## Temporary Closure of PRowS and U6006

I should like to comment on the Applicant's Response to my OFH submission on the 09<sup>th</sup> December 2022

John Leitch 20030552

Drawing Title
**FIGURE 3-19A
CONSTRUCTION COMPOUNDS &
ACCESS SUNNICA EAST
SITES A AND B**

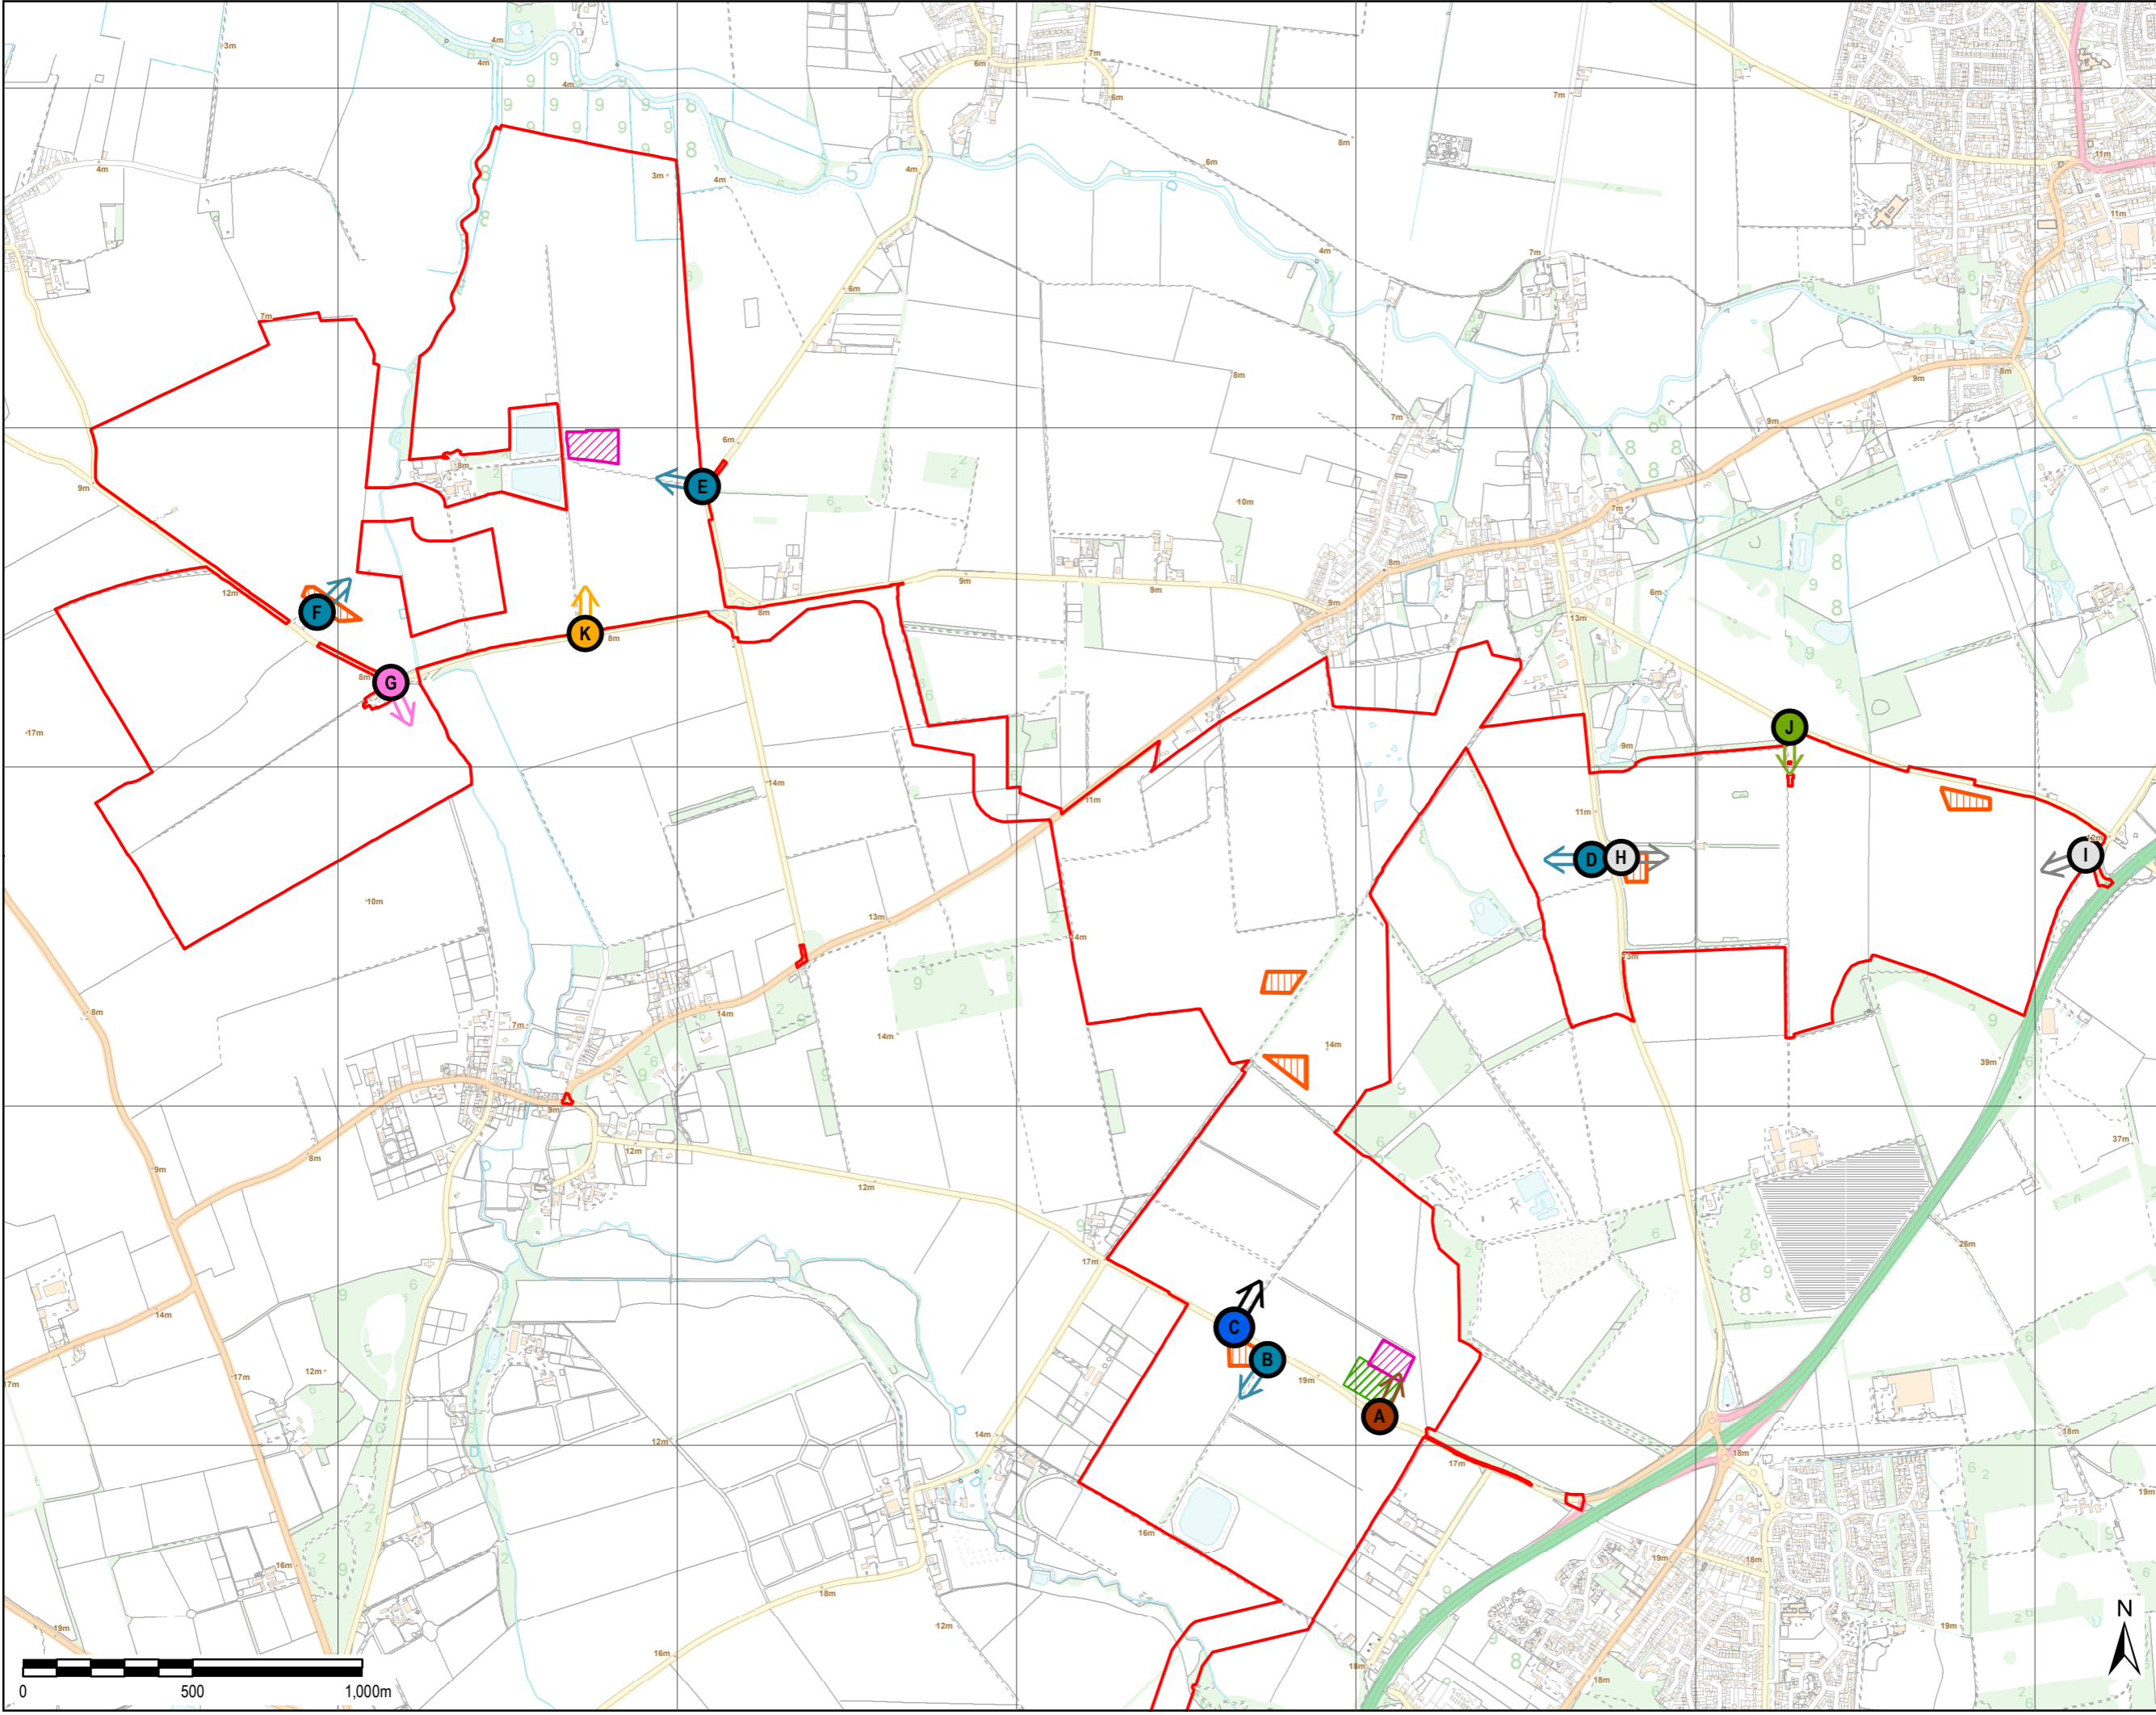
Closure of the U6006, "Duration up to a maximum of one week" Reason for closure, "cable route construction and access to E12 and E24".

E24 is mentioned in the Applicant's response as having potential connectivity with W-257/003/0 which is planned for 3 weeks closure. This statement alone gives rise to the potential for a prolonged closure considering there are 3 cable crossings planned.

According to [APP-246](#) Sunnica East Site B (registered in the legend as Sunnica 3 24 months) is a 24-month construction period. The length of the U6006 being within the order limits of Sunnica East Site B is effectively locked down? The Applicant needs to explain their latest submission.

The proposed perpendicular access road will remain a site access road crossing for 40 years presumably for maintenance purposes?

I agree with Suffolk County Council that the removal of E12 would also take away the tunnelling effect on the U6006 of E12 and E13 and would preserve the integrity of the U6006 and safeguard the impact upon the nesting Stone Curlews in E12 and ECO3. Cable crossings across the U6006 should be drilled rather than trenched in order to reduce unacceptable impact upon trees and negate the need for an asphalt surface.
